Re: Case Reference No. 313322: SHD at Priorsland in Cherrwood SDZ
www.priorslandshd.ie

In response to An Bord Pleanála's invitation to make a submission under the provisions of article 302 (6)(b) of the Planning and Development (Strategic Housing Development) Regulations 2017, the Department of Education would like to make an observation in respect of the proposed school site which directly adjoins the proposed development

Mary Carney
Forward Planning Section

Drawing No.: PLD18-MOLA-XX-XX-DR-A-10-XX102 Status: Revision: P-01

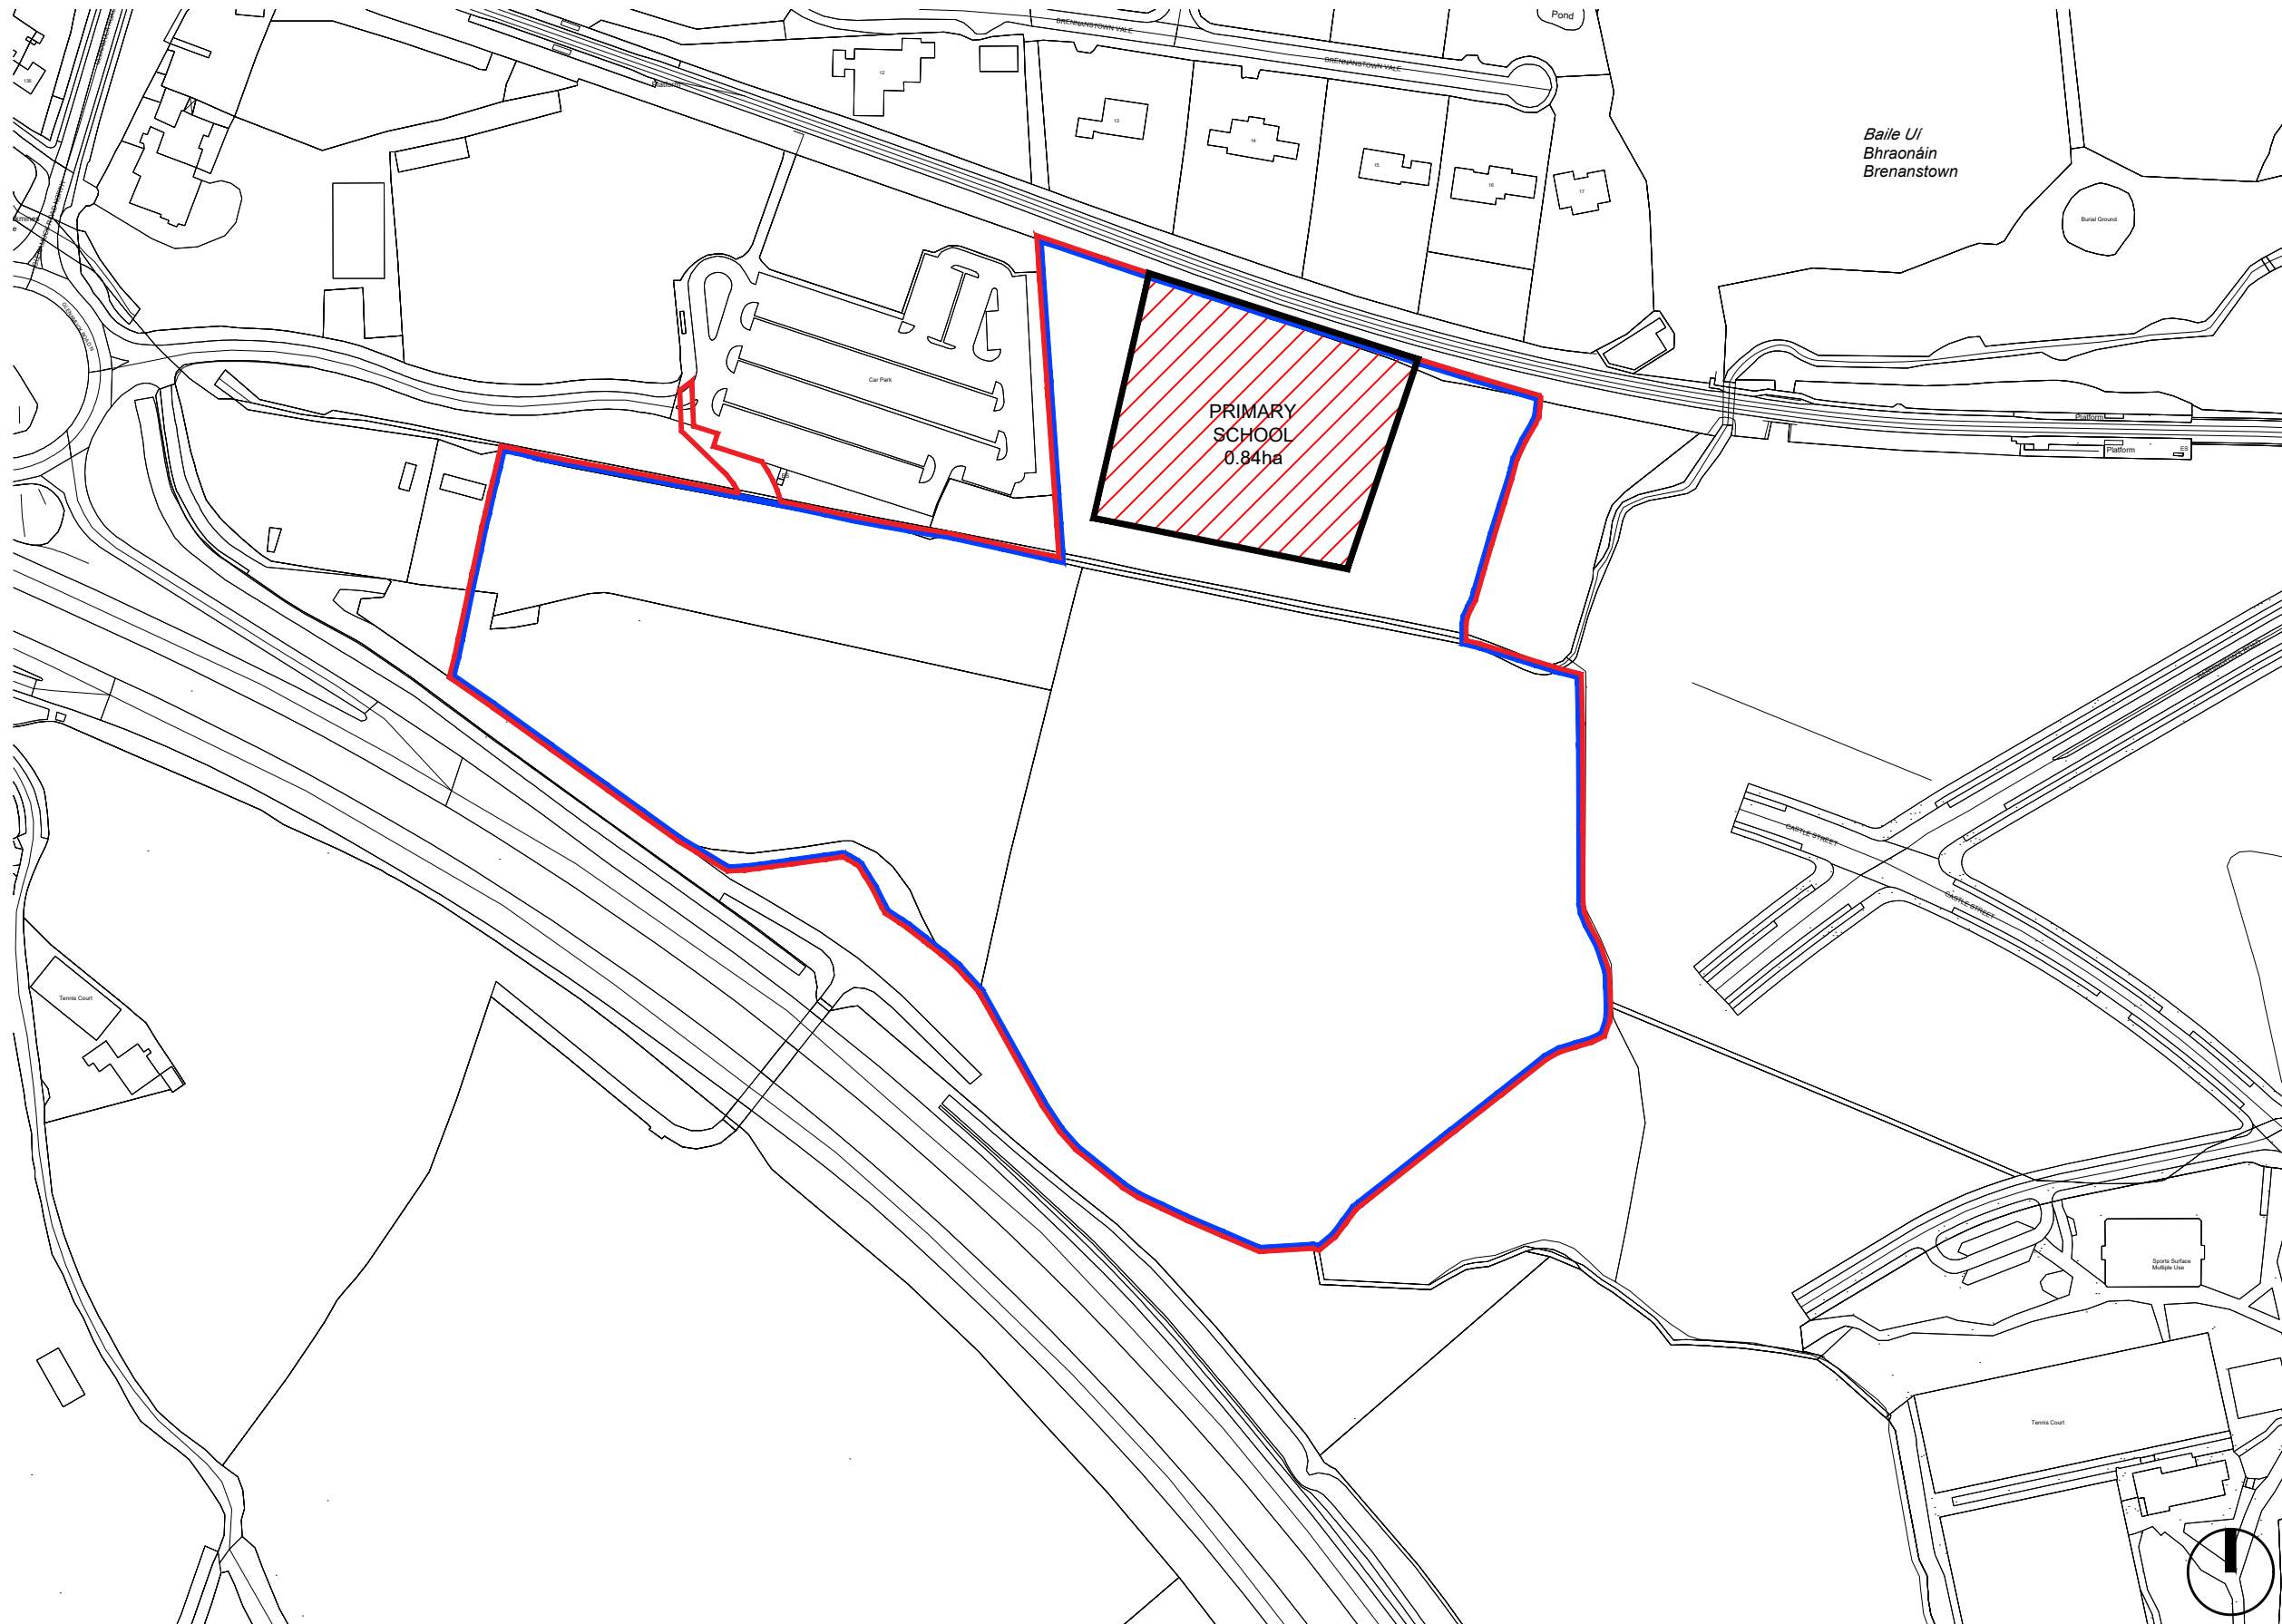
1. The identified school site area is 0.8 Hectares/1.97 acres. This is substantially below the traditional school site area which contains sufficient independent external amenities and facilities. However, there is an acknowledgement that due to the scarcity of land in urban areas such as this, it is not always possible to achieve the ideal site size for school buildings. Where some of the elements required for a school site can be provided outside the designated site area (e.g. traffic management, parking, playing fields, etc.), where it is possible to provide multi-storey (above two storey) buildings, and where separation areas can be reduced due to the nature of permitted development on and adjacent to the site; then smaller sites can be considered (as in this case). The school building intended to be provided here will cater for a likely 600 pupils. Consequently, there is a need for an appropriate level of external facilities and amenities.

- (i) The Department will not have any capacity to modify the transport infrastructure as part of a future planning application. The Board is therefore asked to determine and confirm that the transport infrastructure proposed under the current SHD application and its Mobility Management Plan and Traffic and Transport Assessment (TTA) is deemed to incorporate all future projected traffic and transport needs for a school of 600 pupils (24 classrooms) plus a Special Needs unit. The TTA needs to take account of disability transport to serve the school.

- (ii) There is insufficient land for play and recreational amenities to meet the school's need on the school site. However, the SDZ planning scheme provides adjoining open green space. For a school to operate successfully on the school site, it is necessary that the use of the adjacent green space is confirmed and embedded through a protected and transferable covenant (or other appropriate type agreement) confirming access rights and exclusive school use during school-term and for the operational hours of the school day.
